MEMORANDUM

TO: City of Portland – Planning Board
FROM: Jim D. Wentworth, P.E.
DATE : February 21st, 2018
SUBJECT: Maine Medical Center – Constructability Review

Kleinfelder was tasked by the City of Portland’s Planning Department to assist in the constructability review for the vertical expansion of Maine Medical Center’s existing visitors parking garage.

2 CONGRESS STREET - SITE SECTION  
1/16" = 1'-0"

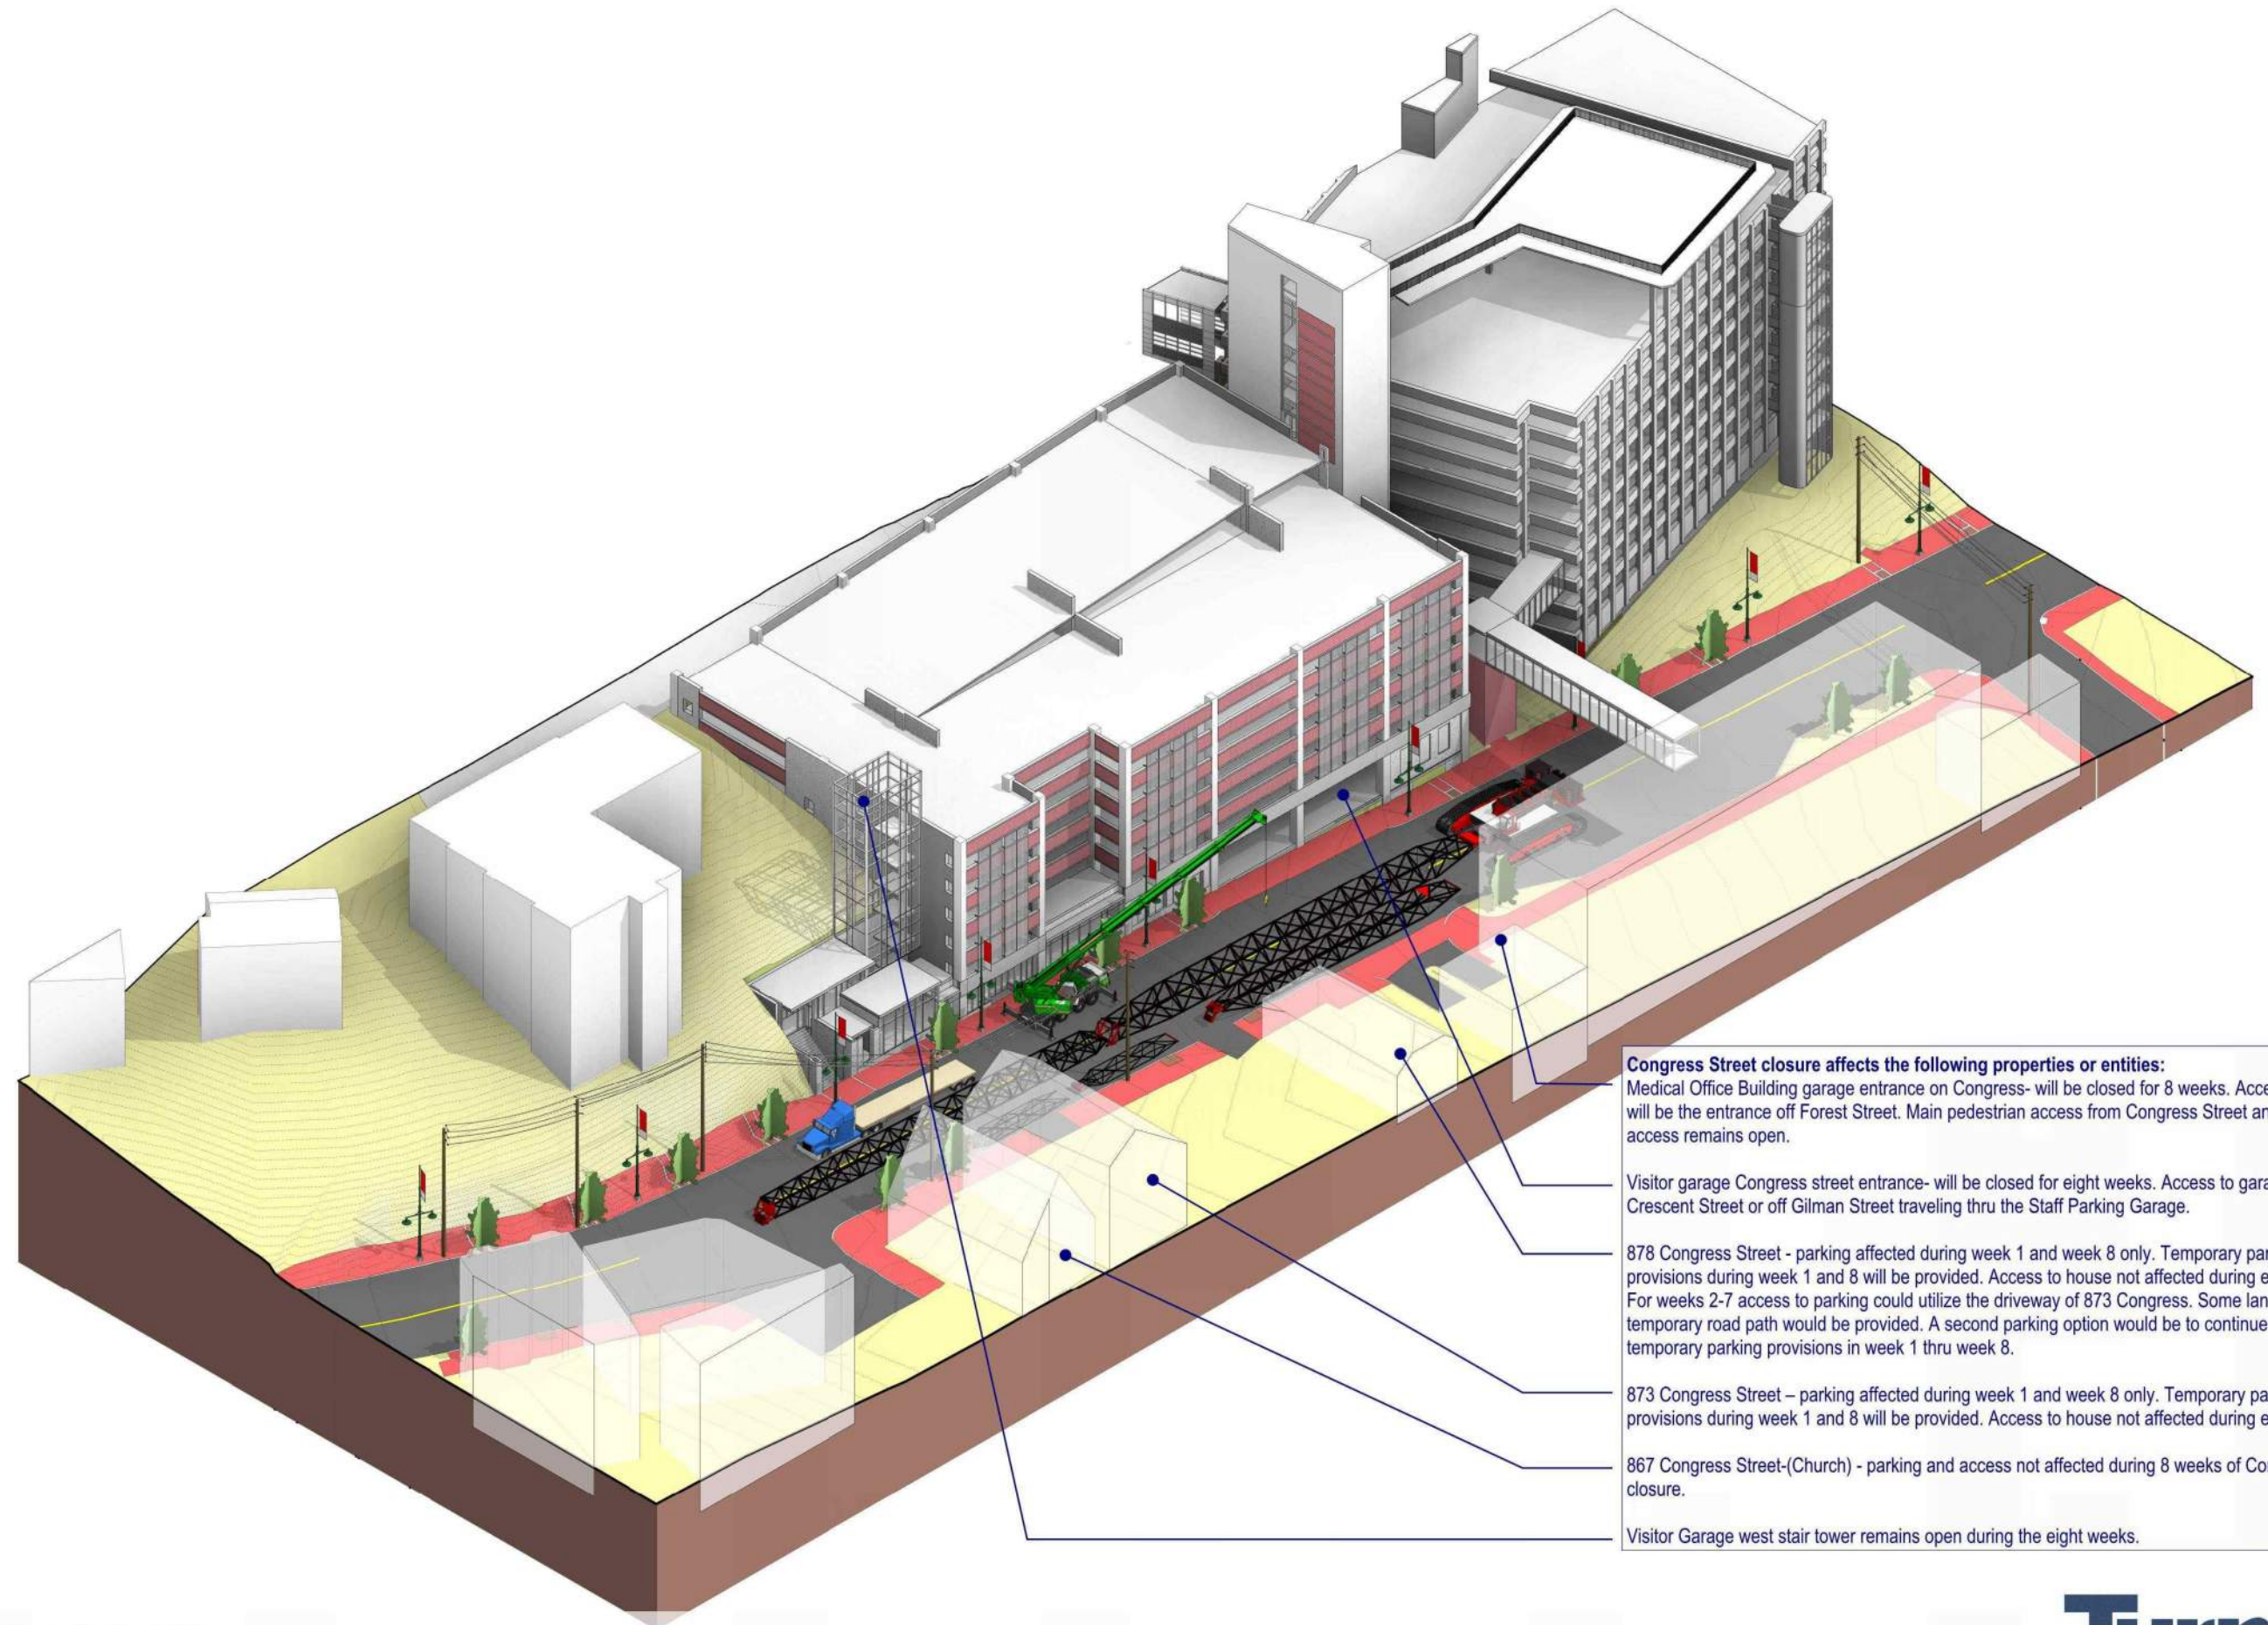
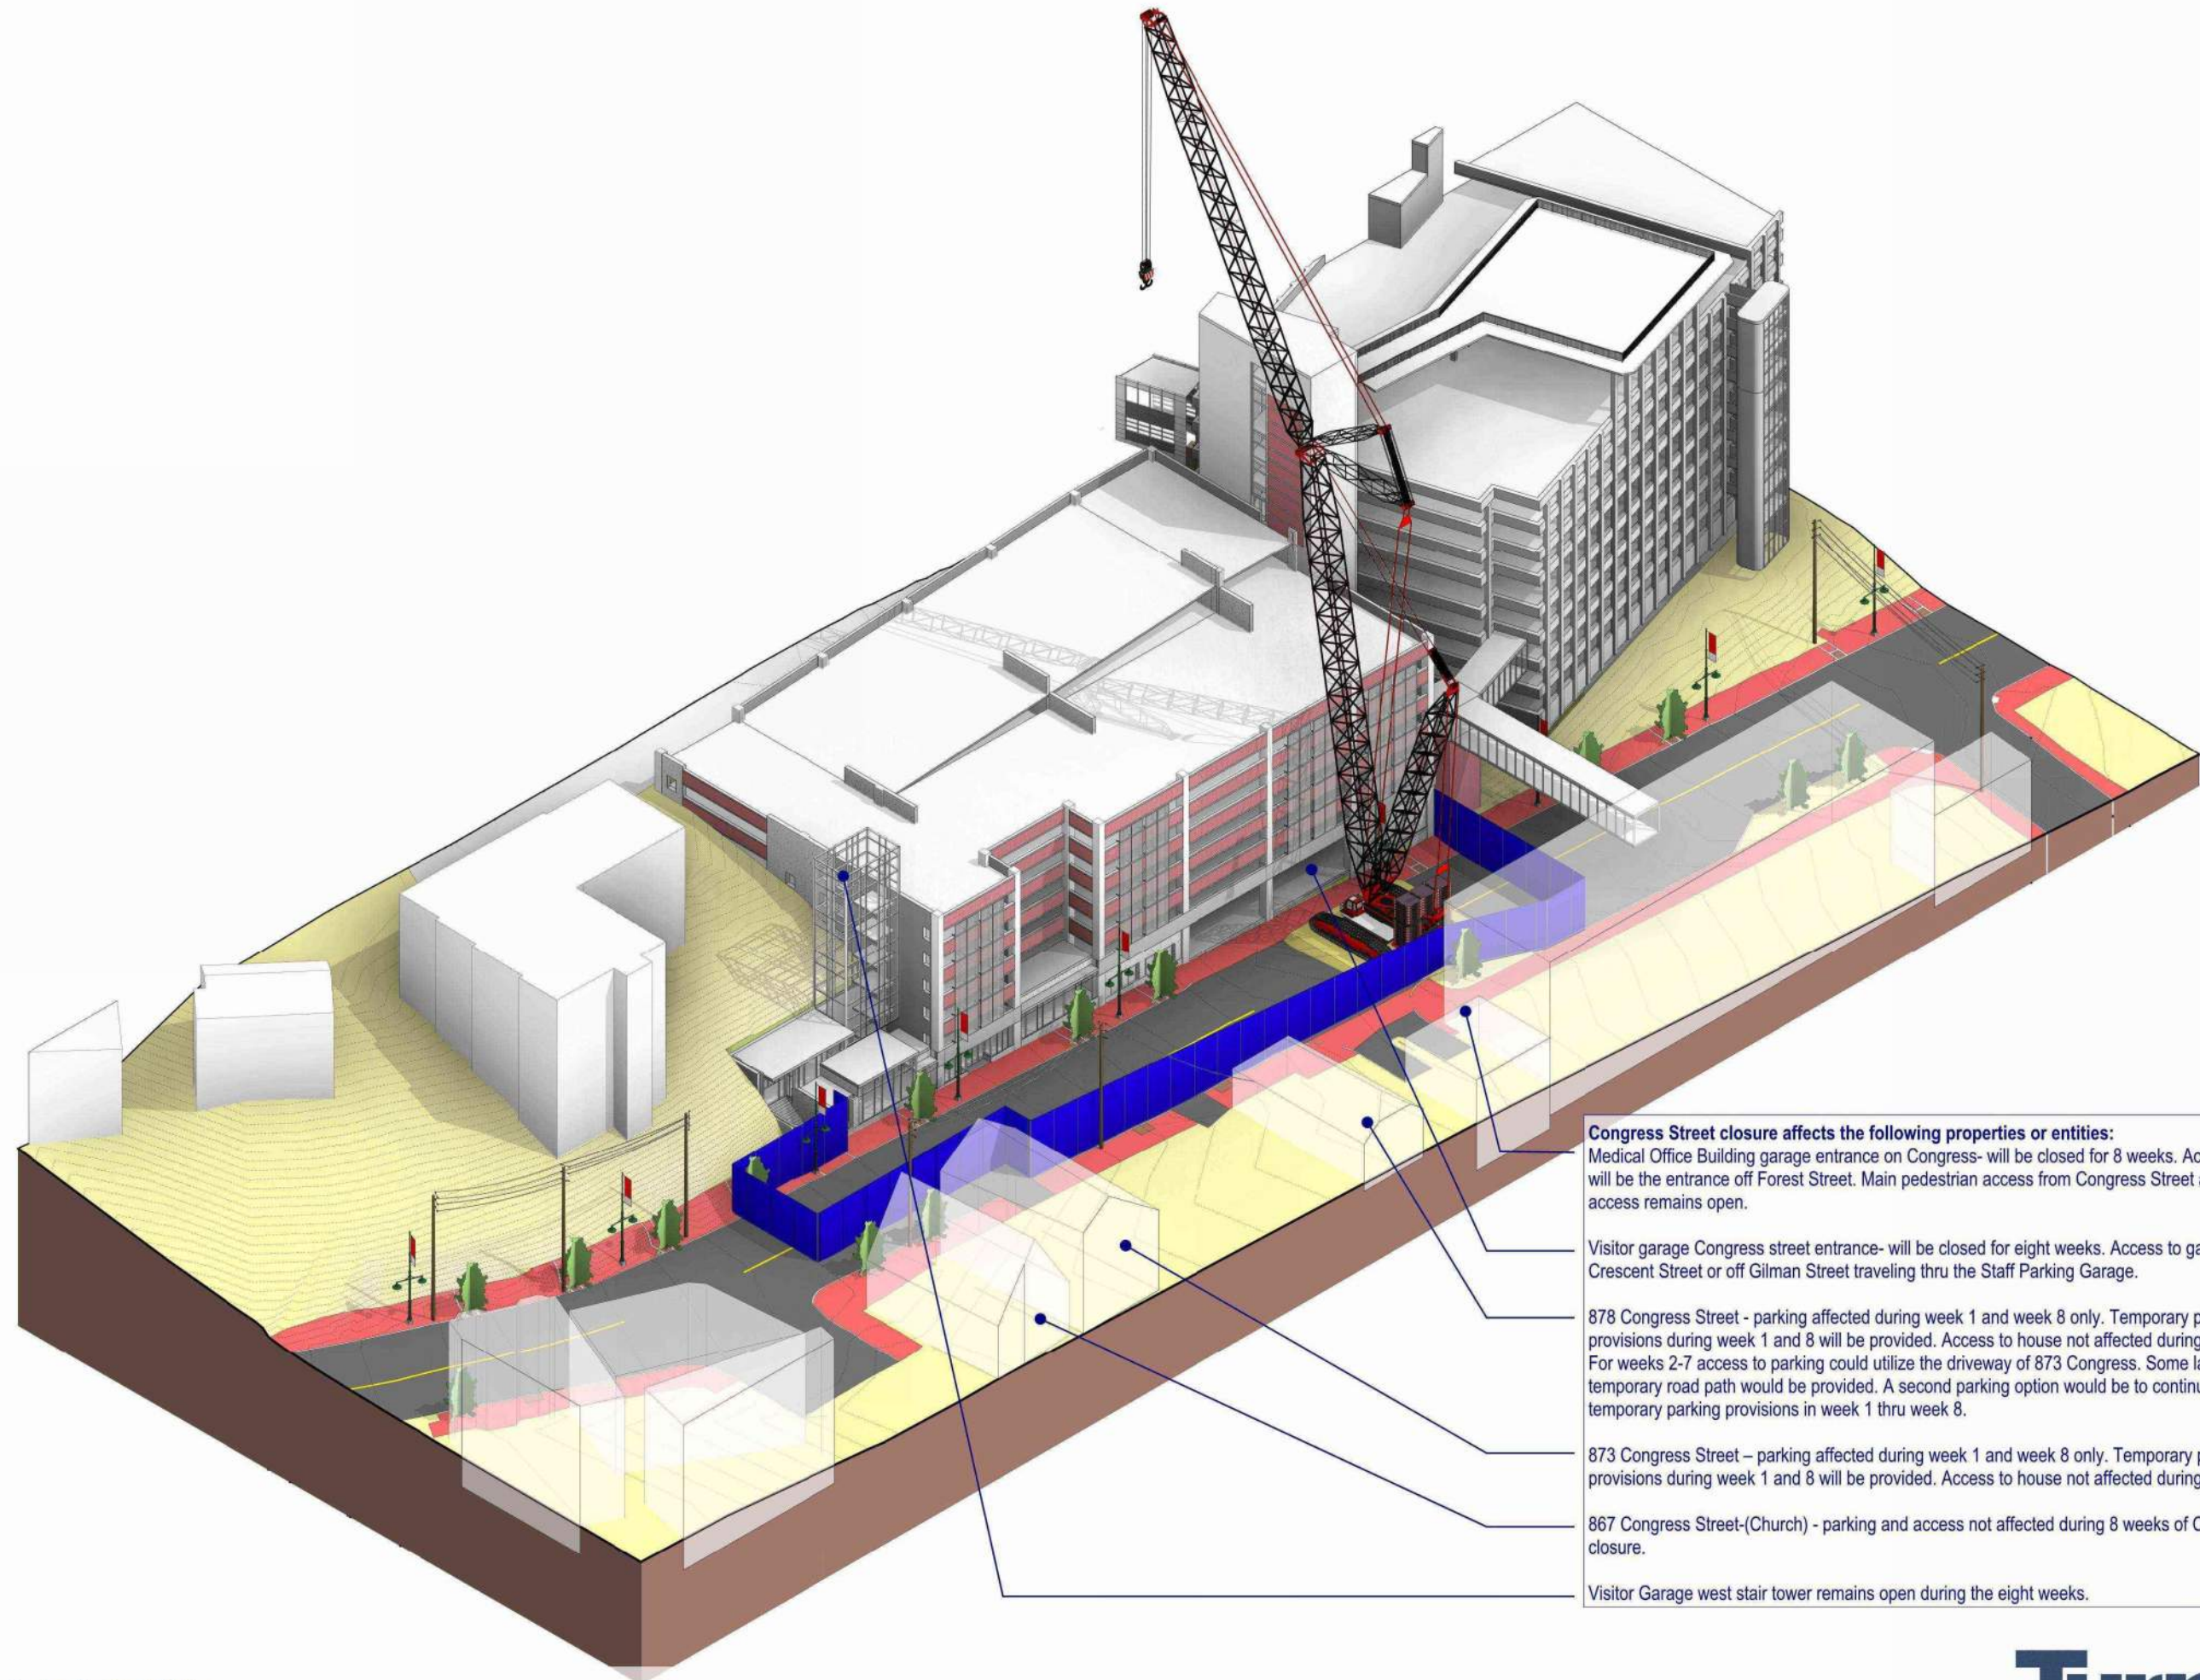
- Congress Street is approximately 43'9"± curb to curb based on cross section provided by Turner.
- The sidewalk abutting the visitor garage is approximately 10'6"± in width.
- The sidewalk on the North side of Congress is approximately 11' ±in width.
- The proposed 440 Ton Liebherr Crane is approximately 45 feet in length from front of track to back of counterweight. This crane configuration takes up the majority of the roadway and overhanging 2-3± feet of the sidewalk.
- The Main boom on the crane cannot operate totally vertical and will use all of the available 10'6"± sidewalk area to face the garage.
- There is no available *safe width* for emergency or passengers vehicles to travel through the area based on the crane operating parameters.
- There is limited available width (7-8 feet ±) for protected pedestrian traffic along the North sidewalk.

- This option has similar site and crane parameters as Option 3, but calls for a shutdown Congress Street for 8 weeks.
- The 440 T Liebherr crane configuration is needed to reach up and over existing parking garage for lifting and reach capacity reasons to install the 30 Ton precast Double tee beams.

- A mobile crane does not have the 30 Ton capacity to reach up and over the building.
- The 440 T Liebherr crane will have two sections of crane boom: Main Boom-161 feet, Jib-161 feet. (320 ± feet).

- A 300 foot length of Congress from pedestrian skybridge to Weymouth is necessary to assemble the crane along with its boom and jib.
- A single phase power utility line exists at corner of Congress and Weymouth which will not affect boom assembly.

- There is no additional street or sidewalk width with this crane configuration to safely use this option with emergency vehicular traffic.
- Delivery of the 85 foot long precast units for this option from Weymouth to Congress is feasible.

*Based on the information provided and reviewed, **Option 4 is recommended.***
